From: Michael Eastham
Sent: 19 January 2021 14:23
To: Planning Scanning
Subject: FW: 22995 - RE: A/166/20/DOC - Manor Nursery, High Street, Angmering

1. We have now replaced the Bypass Separators with the Hydro International Downstream Defender product (Vortex Separator) which was previously approved for the large Cala Homes residential development at Shopwyke Lakes, Chichester, information attached.
Please find attached the 1 in 1 year plus 40%CC calculations for Networks 1,2 and 3 which determine the design flow for each of these units together with the attached technical details which demonstrate the units are of a sufficient size. The units have also been sized to accommodate the peak flow generated by the 1 in 100 year event plus 44% CC.

1. The impermeable areas plan supplied does not clearly show the areas draining to each soakaway. E.g. the areas draining to soakaways 8 and 9 are poorly defined. Please can the applicant supply a better impermeable areas plan which clearly shows the areas draining to each soakaway and which areas have had 10% urban creep allowance applied. 60_Network Areas Plan has now been updated for clarity and the drainage areas for SA 8 and 9 is now mo

CLIENT Roffey Homes Ltd	
PROJECT Manor Nurseries Site Angmering	
TITLE Proposed Maintenance Ownership Plan	
DRAWN P Reynolds	DATE Dec 2020
ENGINEER S Burgess	CHECKED
SCALE 1:250 @ A1	PROJECT NO. 22995 Dwg. No. REV. 120

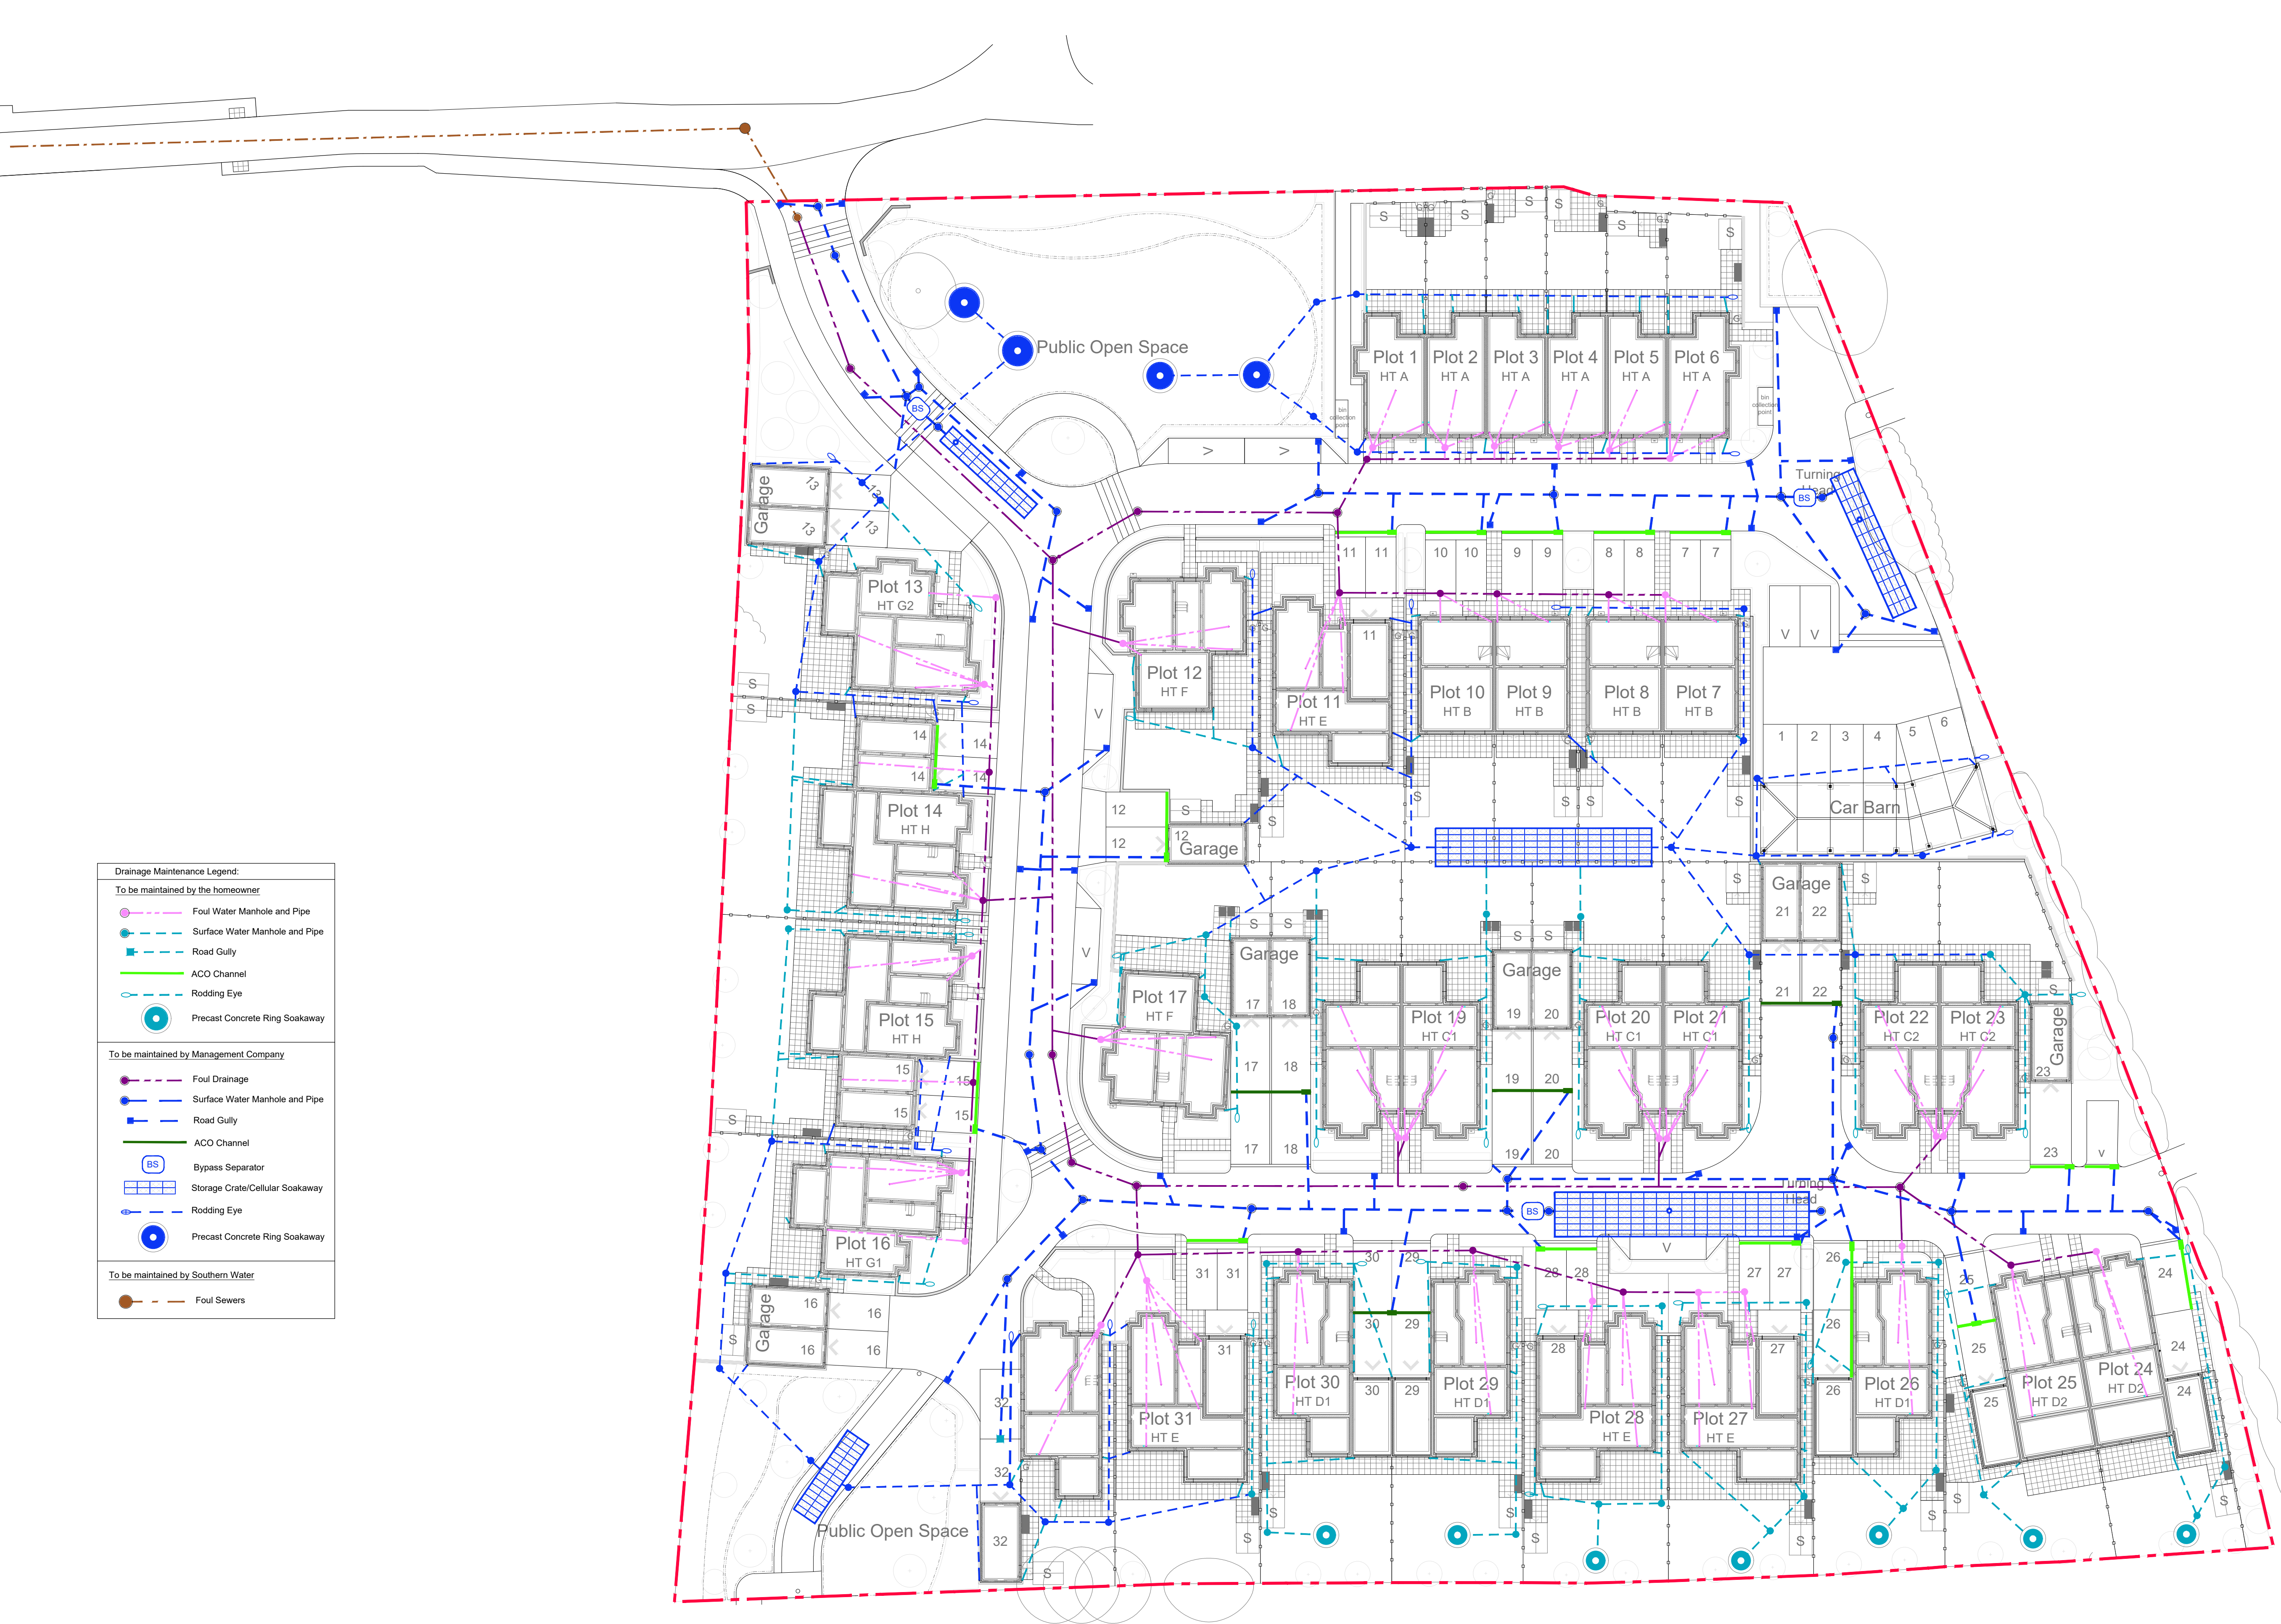
7. (Relating to previous comment no. 10) The maintenance manual does not specify how maintenance will be funded, I presume a charge will be levied on residents and this will be included within the deeds. Please detail how money is to be secured.

8. (Relating to previous comment no. 10) Please detail the requirements for maintenance of the infiltrating components, e.g. look at table 13.1 in C753.

3. Maintenance Manual updated as per your comments.
4. Maintenance Manual updated to include details on maintenance for the soakaways as per Table 13.1 in C753.

TYPICAL SOAKAWAY DETAIL
(LESS THAN 3m DEEP)
(Scale 1:20)

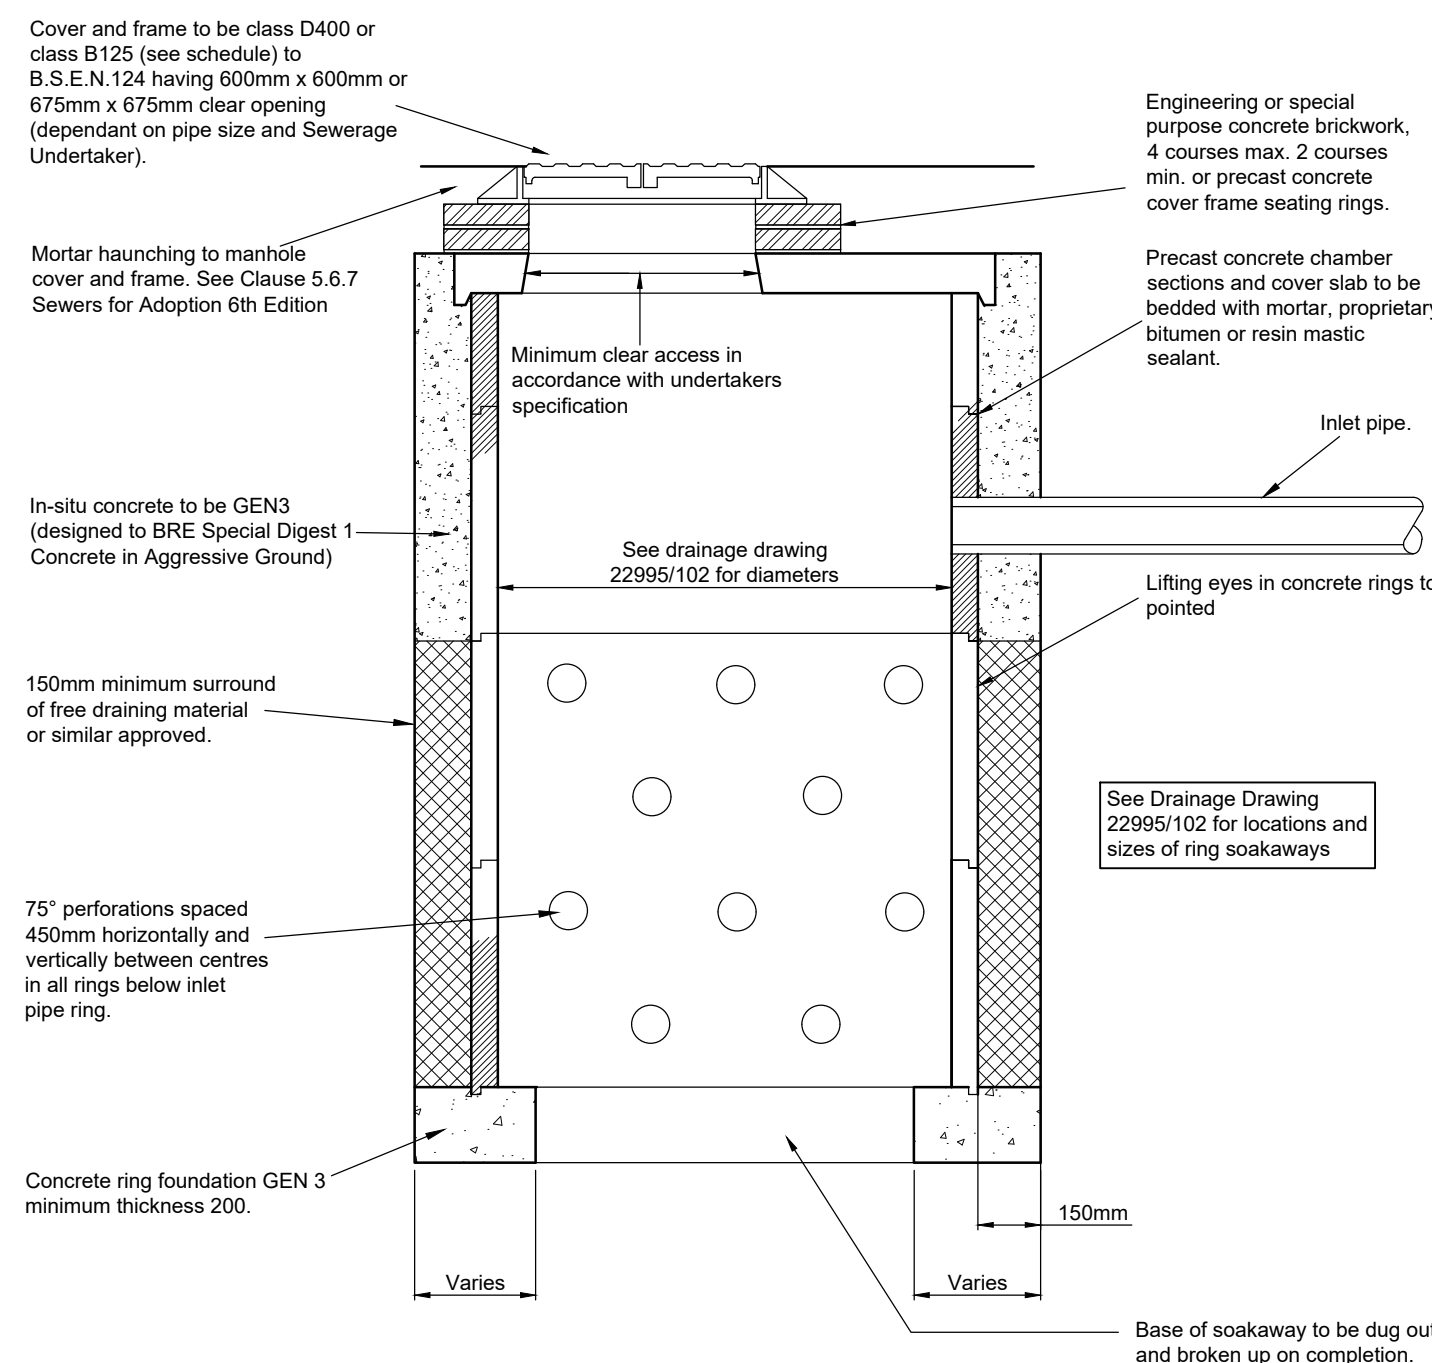
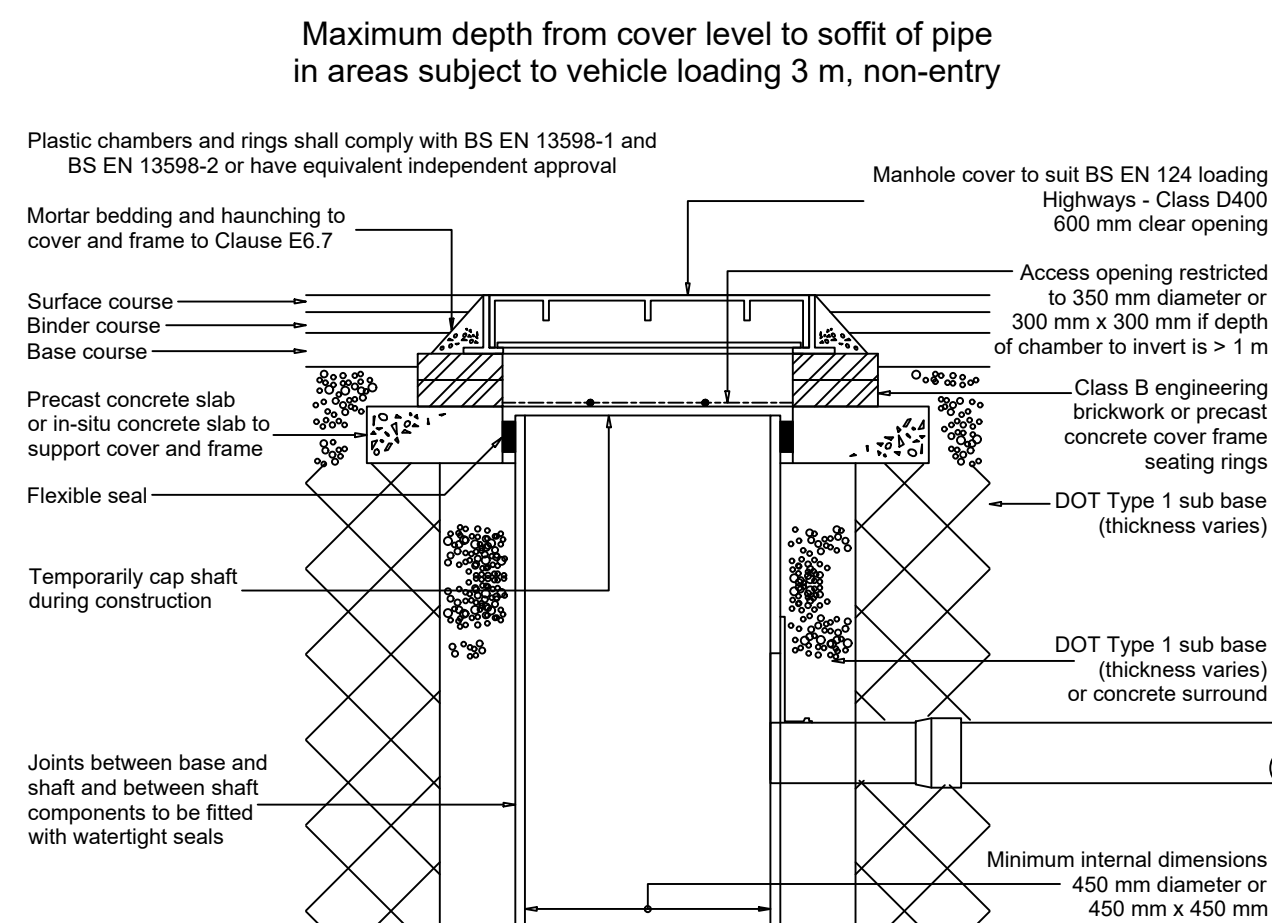
8. The calculation details for SA 7, SA8, and SA9 are different to those on plan. Please correct so that they are consistent. Calculations updated.
9. Construction detail drawings need to be provided, as per our checklist. Please see 502__Construction Details.

2. With reference to the above change with have also now updated the construction details for the soakaways to include 300mm minimum depth of underlying soil drainage media to add a further level of treatment to the system. On top of the already adequate level of treatment provided by the Downstream Defender this extra mitigation would provide the below additional mitigation index:

APPROX WEIGHT:	4.28 t	MATERIAL:
REFERENCE:	22995	
DRAWING NO.:	C 1320-1000-01000	
SHEET SIZE:	A3	SHEET: 1 OF 1 Rev: A

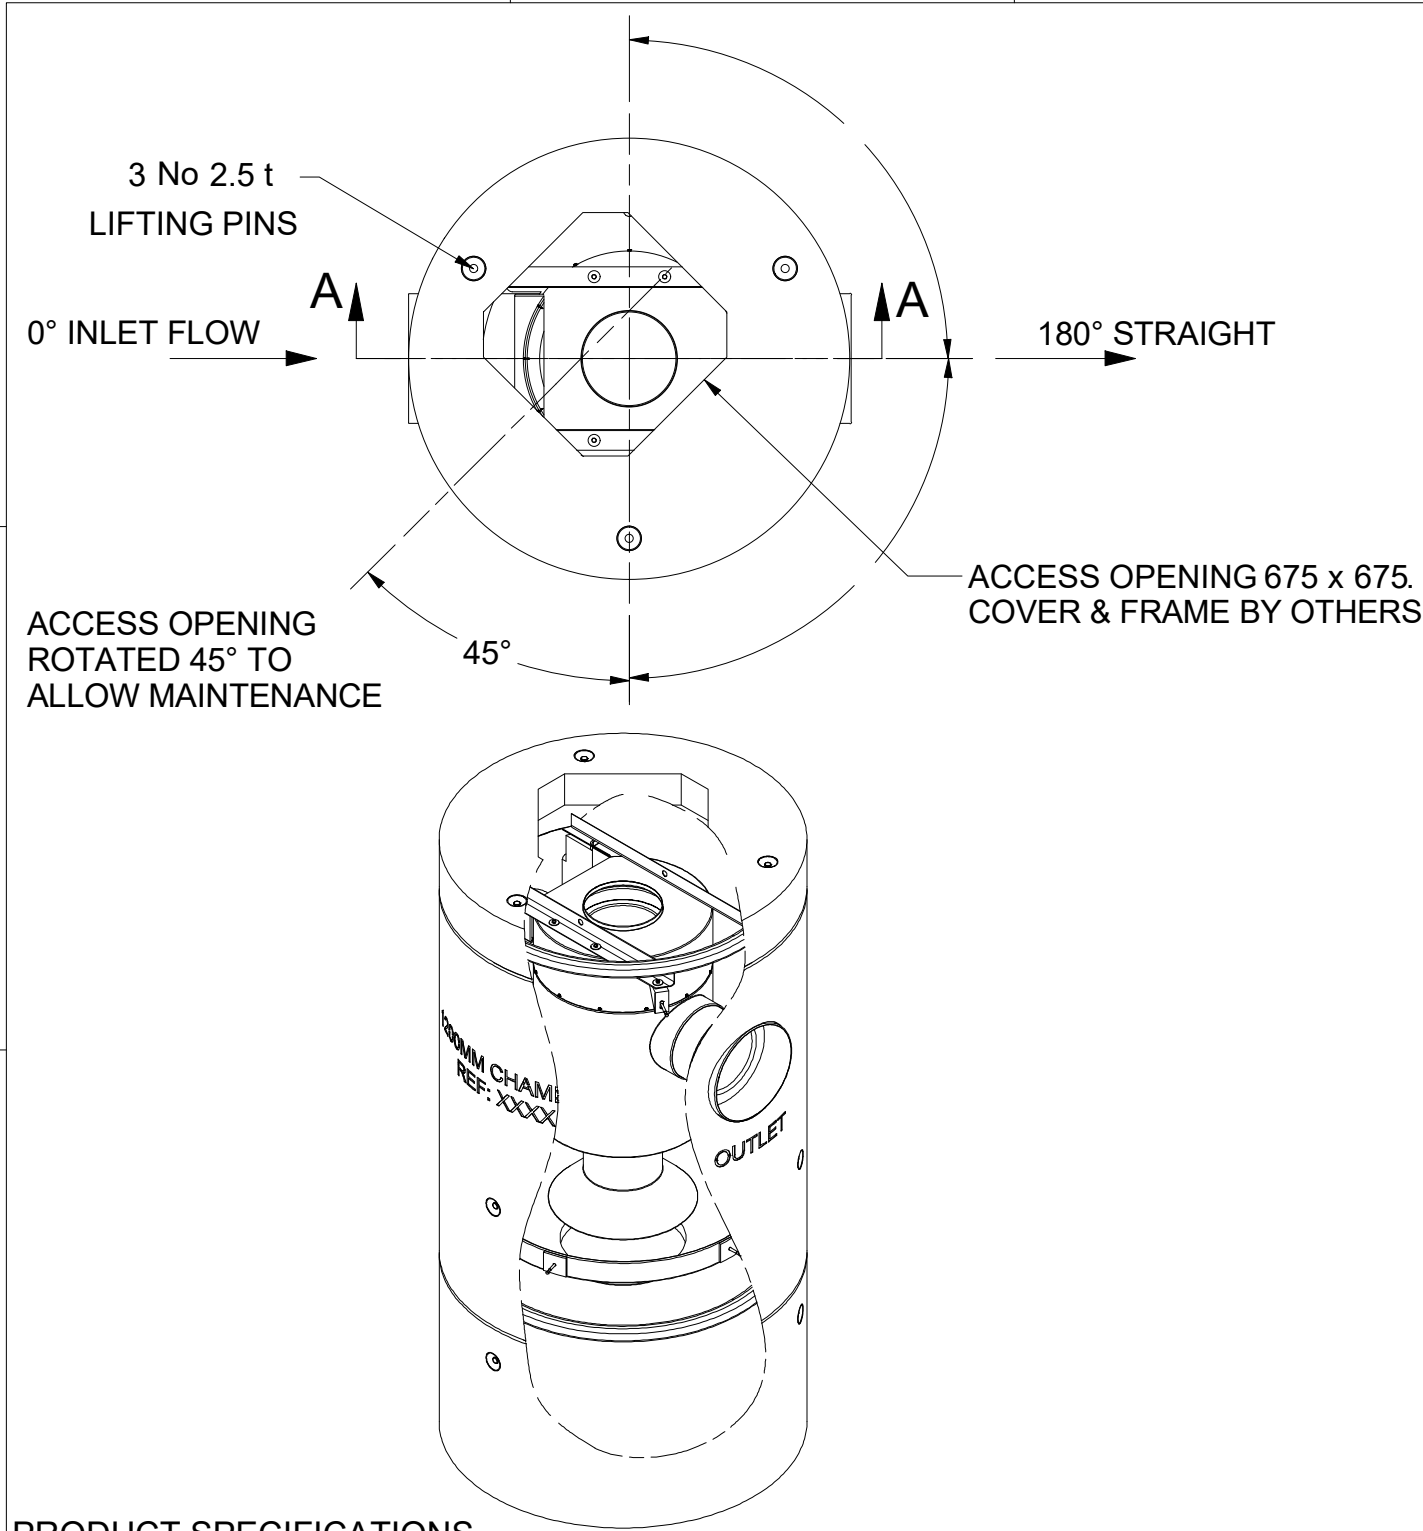
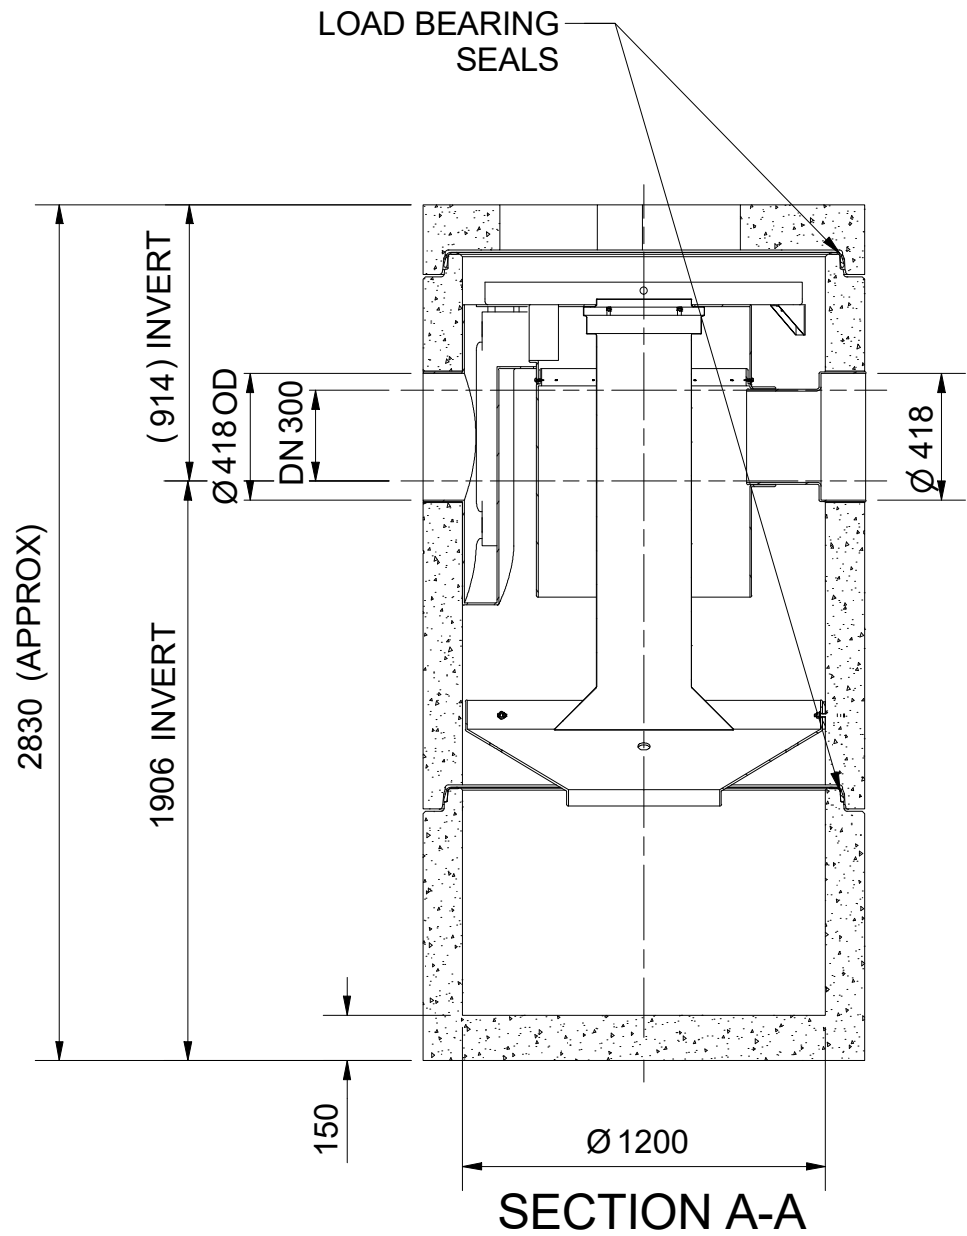
5. (Relating to previous comment no. 4) Please provide evidence that the bypass separators are of a sufficient size that they will treat the 1 in 1 year plus 40% climate change event flow. I.e. please supply calculation results for the networks with separators on for the 1 in 1 year plus 40% cc event to demonstrate what flow is occurring through the network in this event.

6. (Relating to previous comment no. 4) The documents provided did not specifically detail the hazard mitigation indices being achieved for total suspended solids, metals, and hydrocarbons. Please detail. Bypass separators are known to not be effective at removing soluble pollutants, how are these being removed?
